**Pratt Zoning Setback Variance**  
**File Number VA-20-00013**  
**FINDINGS OF FACT, CONCLUSIONS OF LAW AND DECISION**

Requested Action: David and Doretta Pratt, property owners, submitted a zoning setback variance requesting a reduction from the 25-foot front lot line setback requirement for the Rural 5 Zone in KCC 17.30A, which would result in setbacks along the southern property line from 1-foot to 24.5 feet, as the orientation of the property boundary resulted in a setback range. During the review process it was determined the setback request would be adjusted to 5-feet to 24.5 feet along the front property line. This variance is requested to build a single-family residence.

Location: Parcel #240134 located at 301 Pine Glen Drive, Easton, WA, approximately .35 miles northwest of the intersection of Nelson Siding Road and W. Cresto Road, Easton WA, in Section 17, T 20N, R 14E. W.M. Map number 20-14-17050-0206.

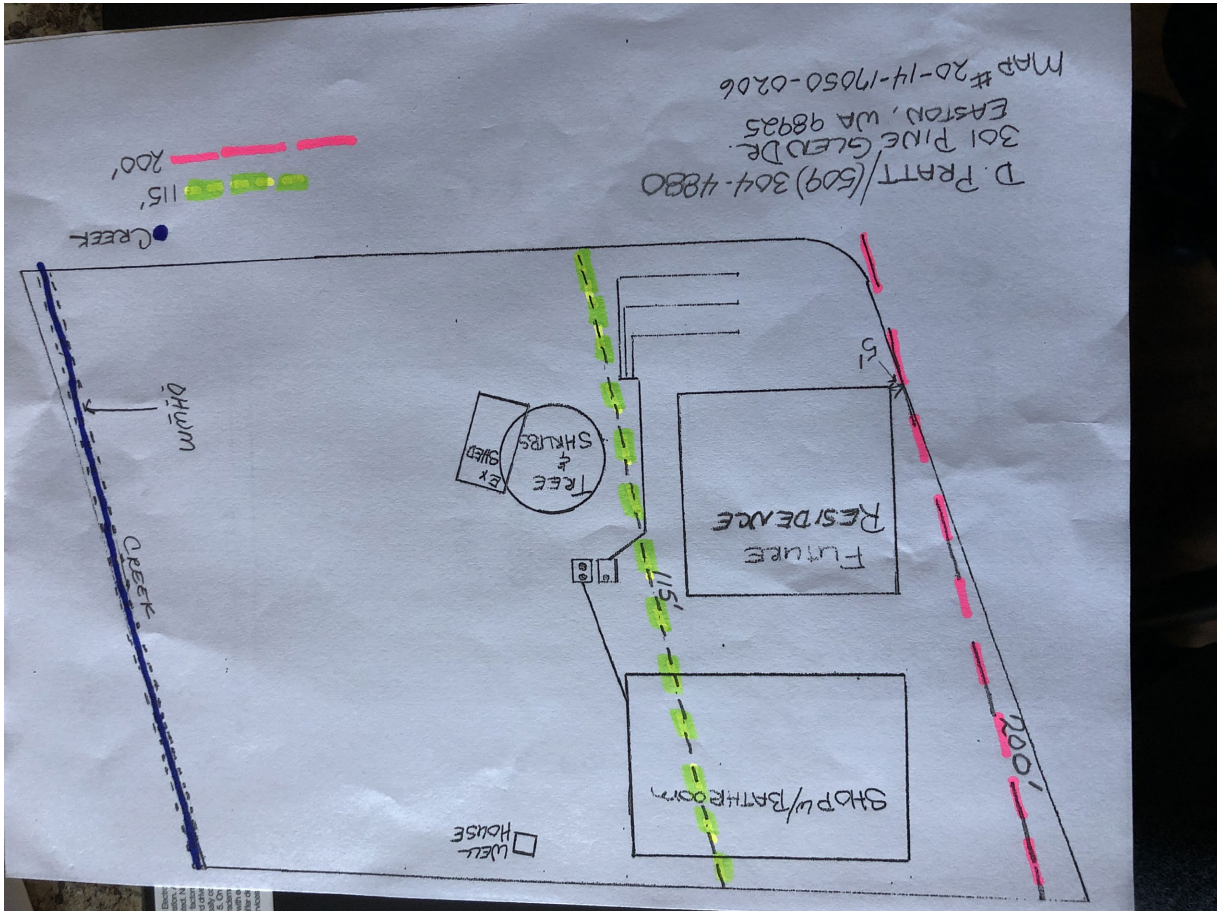
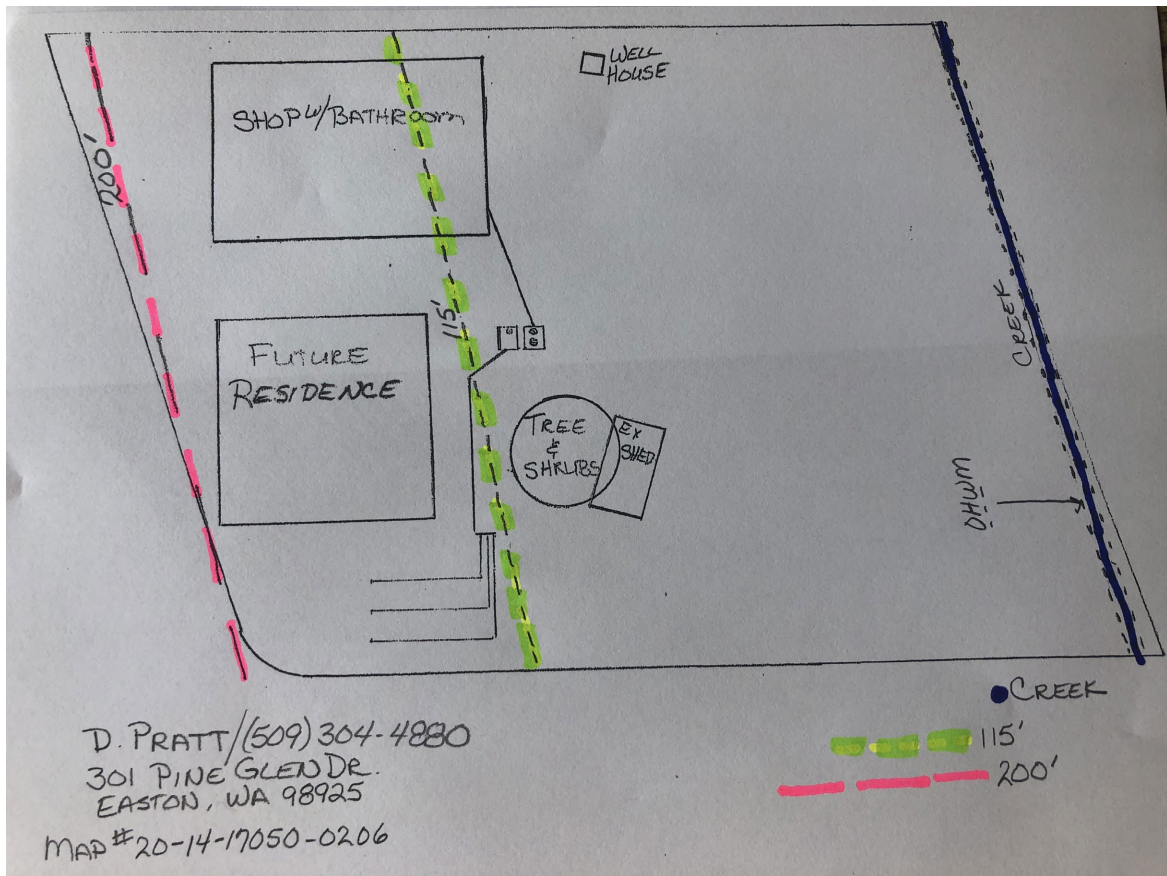
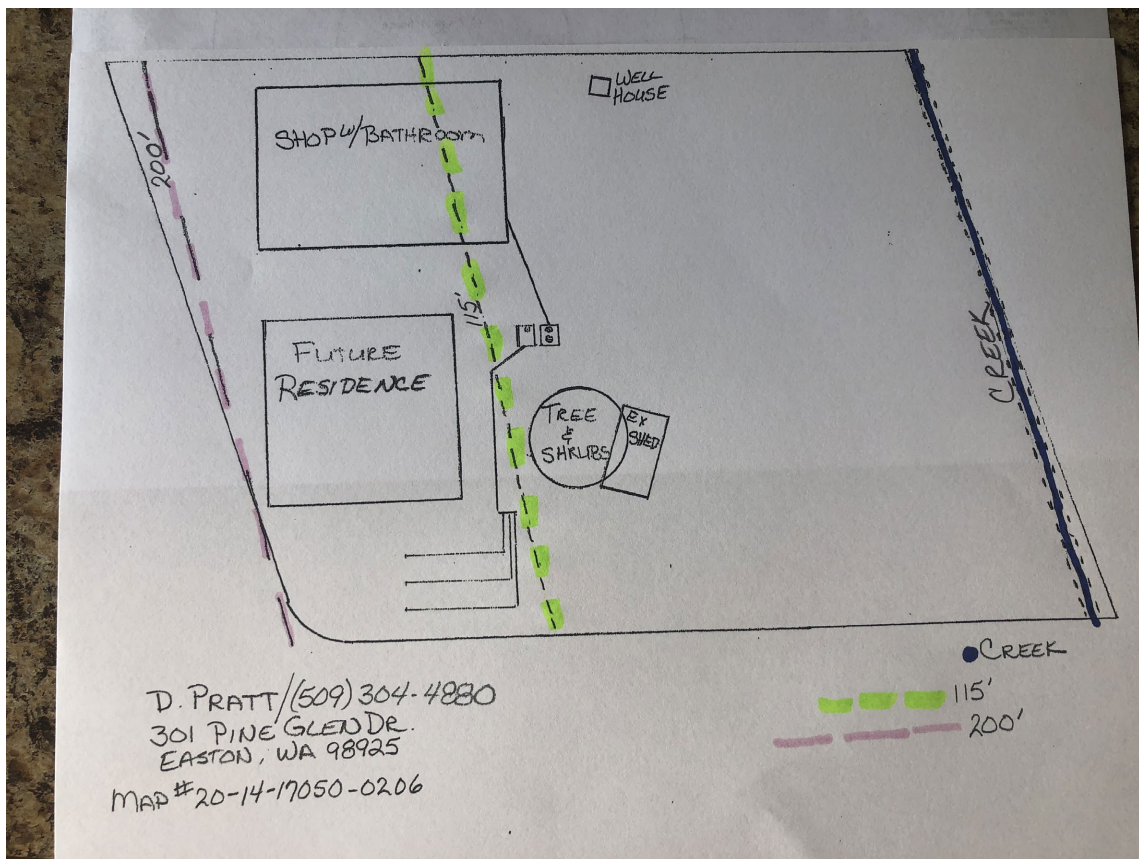
- All necessary KCPW permits are acquired prior to construction for access and any grading over 100 cubic yards of material;
- Requested an updated site map showing the creek set-back requirements, structures, and site features. As the current site map does not show the need for the setback variance and as is, PW would not support the 1' setback due to potential conflicts with future development of the private road intersection;
- All or most of the property is within the 100-year floodplain and will require floodplain development permitting; and
- Recommended requesting the applicant to have the property surveyed to establish the property corners, as they were not established during the original survey.

CDS has provided these comments to the applicant. The applicant has responded to the comments and has provided an updated site map including the 200-foot shoreline buffer, the 115-foot no-build buffer all associated with the Type 1 stream located on the north property line. After an onsite meeting with the applicant and Public Works employees, the applicant hired Bob Bailey, a local surveyor to locate the corner marker of the property. The outcome of this process showed that the original request for 1-foot setback on the southeast corner would actually be 5 feet. Public Works responded with approval of a 5-foot setback minimum for the section of the house located in the southeastern corner of the property. CDS has conditioned this determination to ensure the setback is a minimum of 5 feet from the property line and the applicant shall obtain all necessary permits required by KCPW.
